Consultation Response from KC, Conservation & Design**2024/91460 The Old School, Dean Head, Church Lane, Scammonden, Huddersfield, HX4 0EA****Erection of detached building to create dwelling forming annex accommodation associated with The Old School, Dean Head, Church Lane, Scammonden, Huddersfield, HX4 0EA (Listed Building)****Date Responded: 13.06.2024****Responding Officer: S Pickles****Responding Ref:**

South Elevation

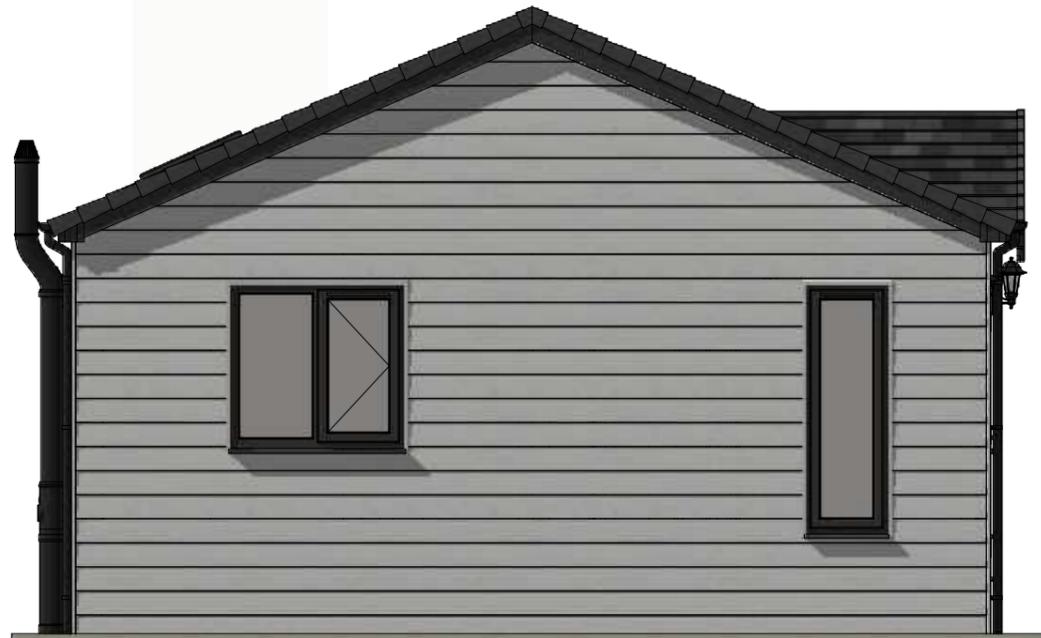
We are however not convinced by the proposed design and material palette. The building appears to reflect more of a mobile or temporary home. The building does not reflect the character and setting of the stated buildings and the wider surrounding area. We consider that the design needs to be amended to reflect a modest ancillary outbuilding. The materials could include the use of some timber cladding, this would however need to be of a natural finish, allowing for the timber to naturally tone down and weather. We would equally expect the roof to be finished in slates, which again would reflect the local vernacular.
